Tenancy 5, Overseas Passenger Terminal, Sydney

Please find herein comments regarding the expected impact on the local wind conditions due to the architectural changes to the proposed Tenancy 5 development at the Overseas Passenger Terminal, Sydney.

Level 01 - Ground Floor

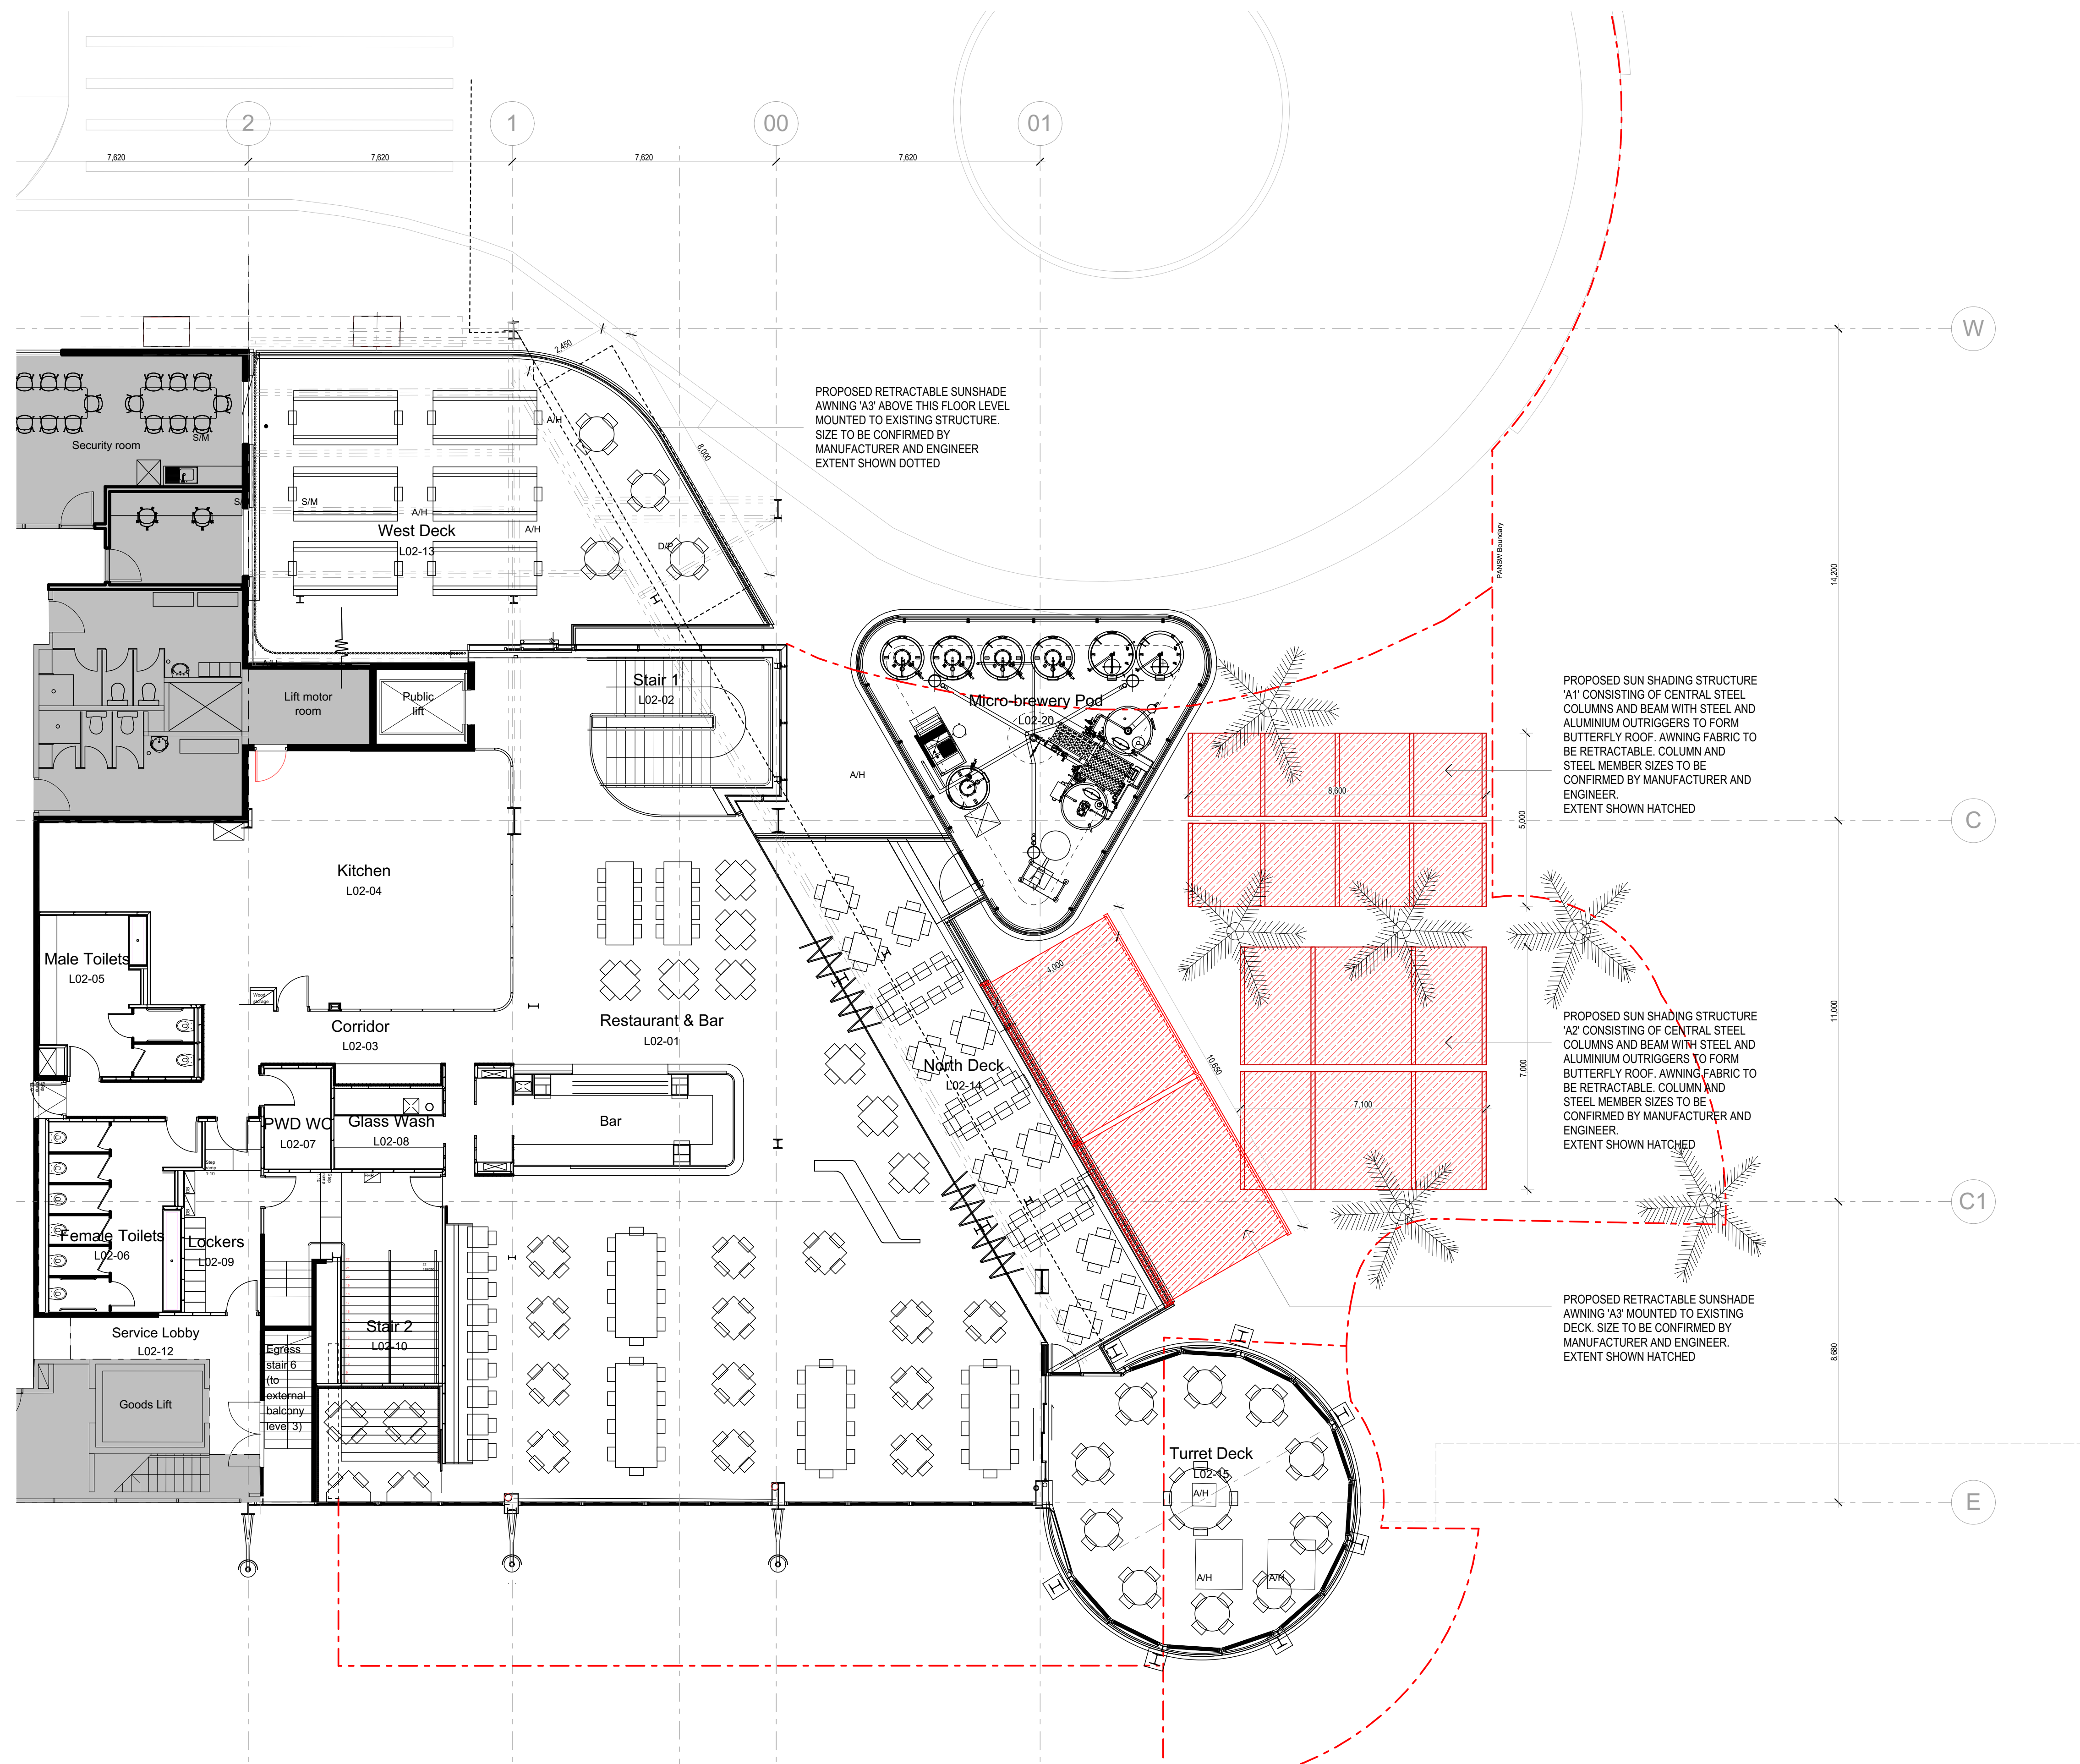
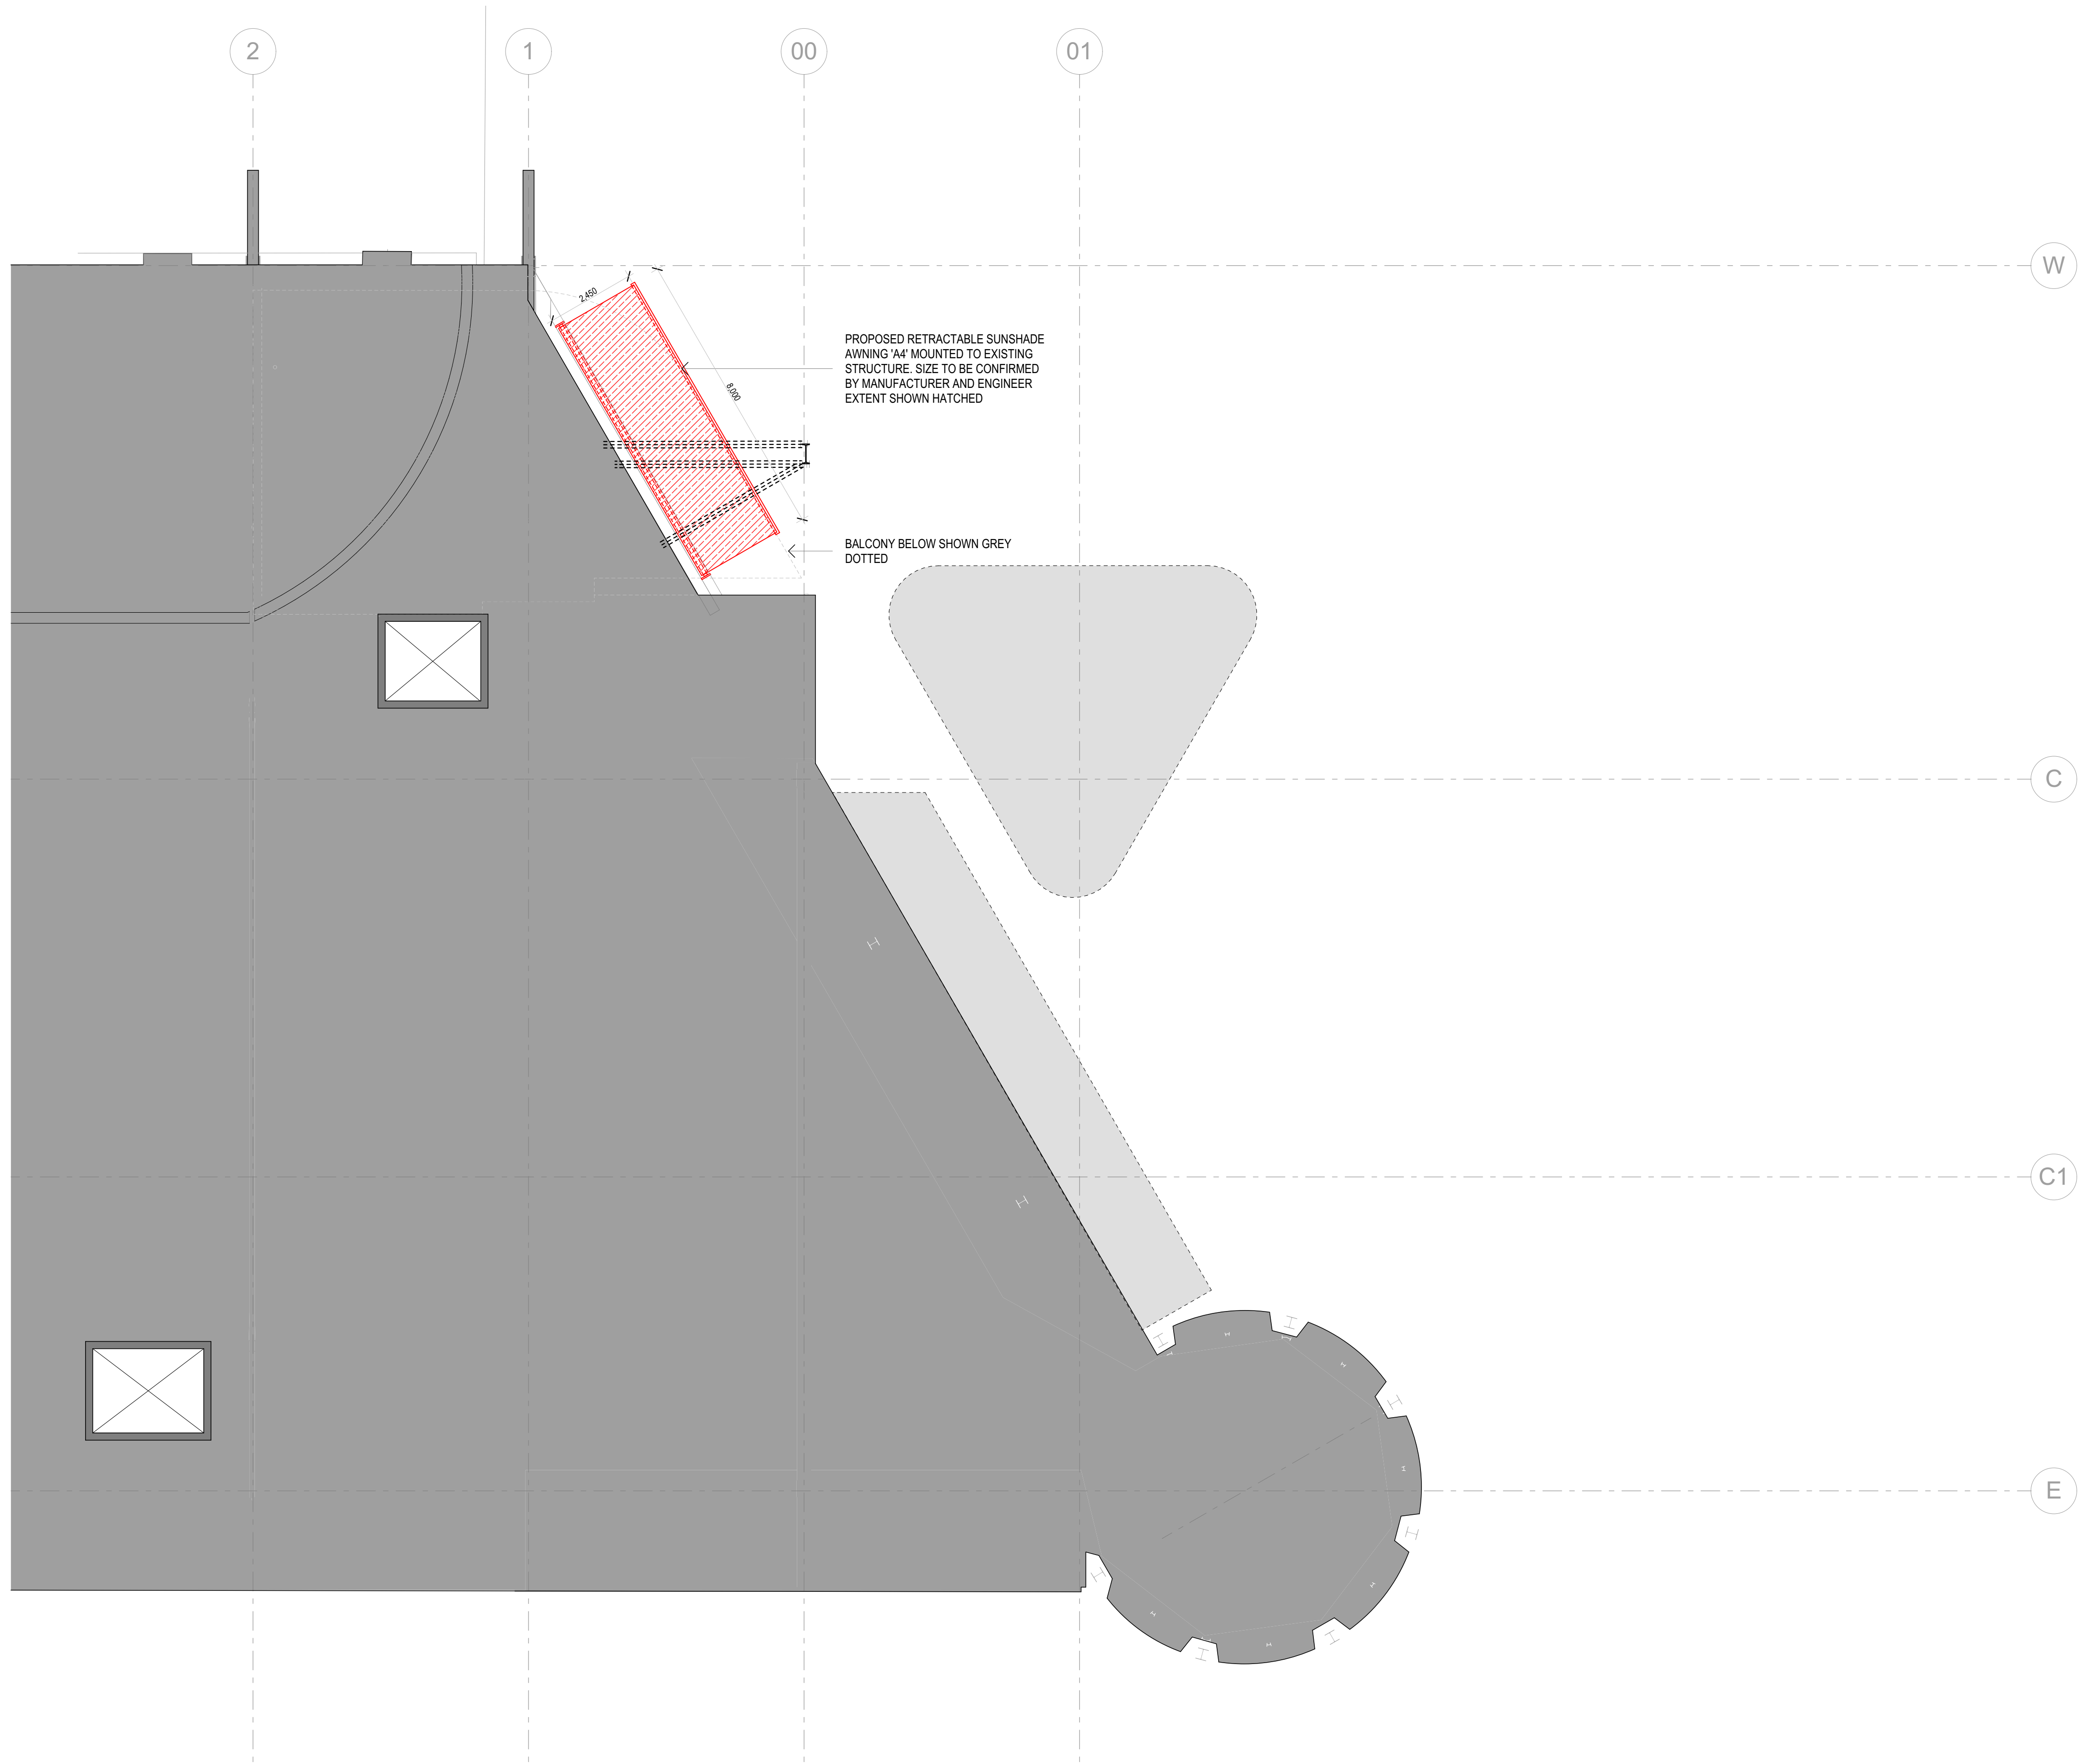
The overall development massing has not changed since the previous wind study reported by CPP in the report entitled Tenancy 5, Overseas Passenger Terminal dated 12 May 2017. There are some minor architectural changes to the development including the installation of four operable horizontal sun-shading elements (3 on ground level, and one on the upper level), and bi-fold doors to the tenancy, Figure 1 and Figure 2.

As the wind flow around this area is expected to be essentially horizontal, the proposed horizontal structures when either open or closed would be expected to have a negligible impact on the local wind conditions compared with the previous design. When extended, the structures would marginally improve the wind conditions in and around the development. The operability of the sunshades and the tenancy bi-fold doors will increase the flexibility of the space from an environmental comfort perspective for patrons. From a wind and environmental perspective, the inclusion of these elements is considered to be beneficial to the design of the development.
